MEMORANDUM

DATE: July 17, 2026

SUBJECT: Monument Ridge East Filing No. 1
RE: Transportation Memorandum
Response to Misty Acres Metro District Comments Memorandum
LSC #S234451

Figure 5
Entering Sight Distance Analysis
Misty Acres Blvd/Monument Hill Rd (Eastbound Approach)

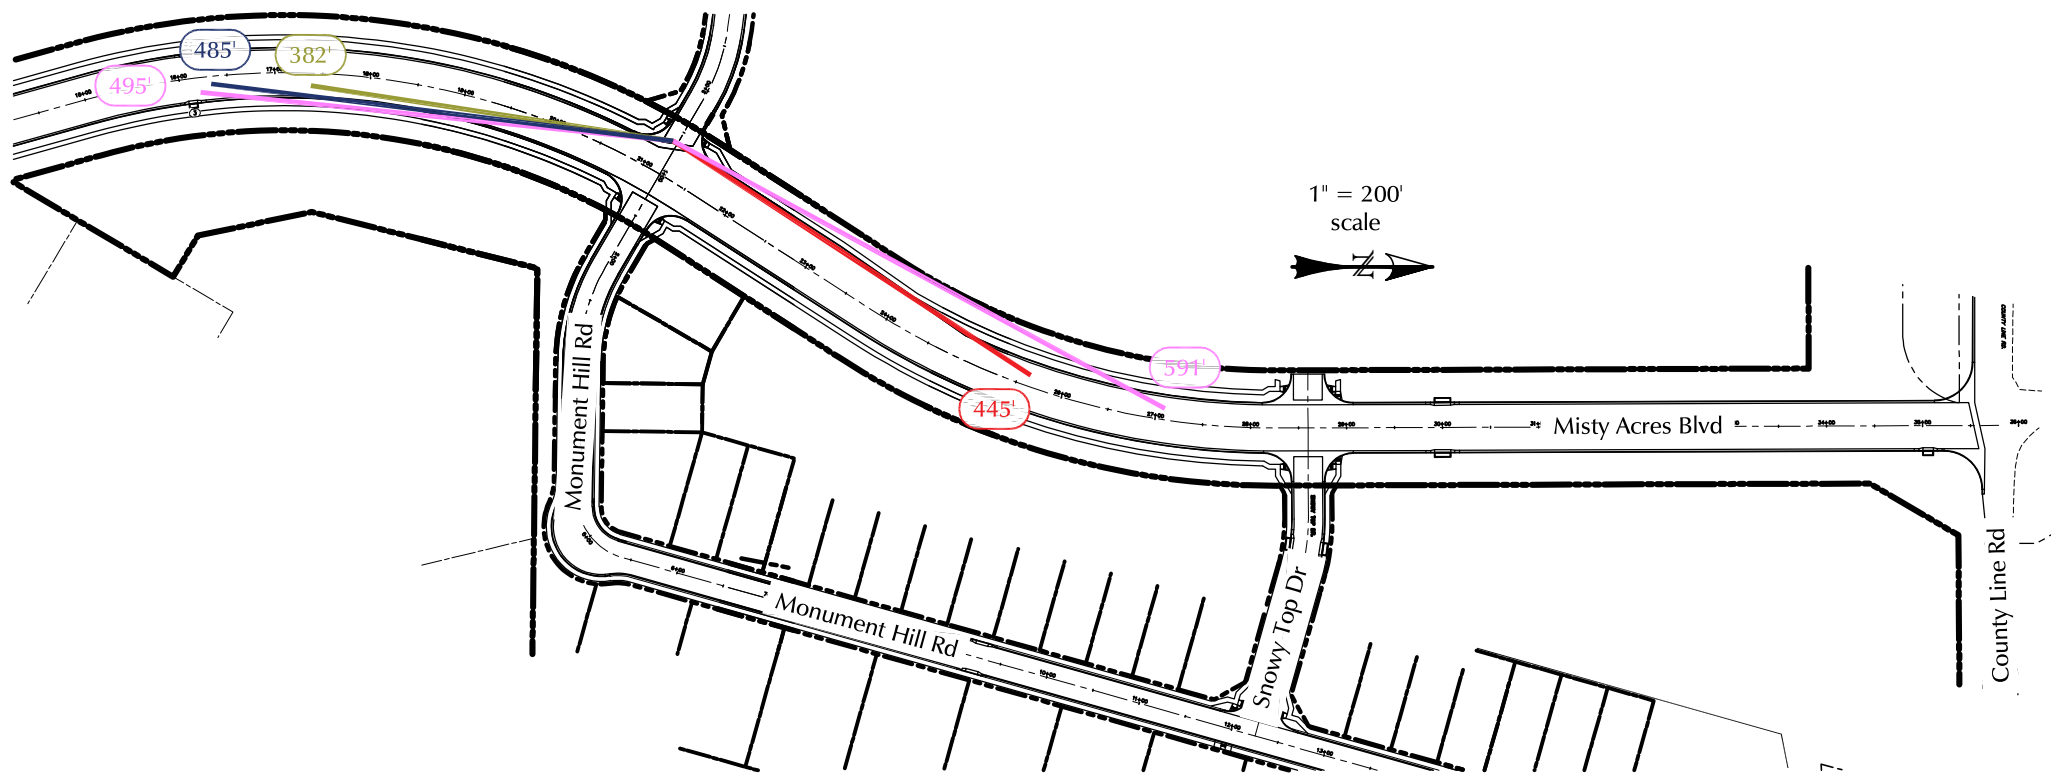
I disagree with their traffic studies. They omit Palmer Ridge High School traffic and the illegal parking on Misty Acres Blvd. There's going to be a lot of collisions around there with increased traffic and inexperienced drivers.

There's also a pedestrian risk with children darting out between cars and short sight lines.

This applicant has no authority to enforce parking regulations and ticket illegally parked vehicles. Regarding sight lines, a thorough evaluation of the sight distance at the site intersections and access points is included in the Filing No. 1 TIS report to verify that county standards for sight distance will be met.
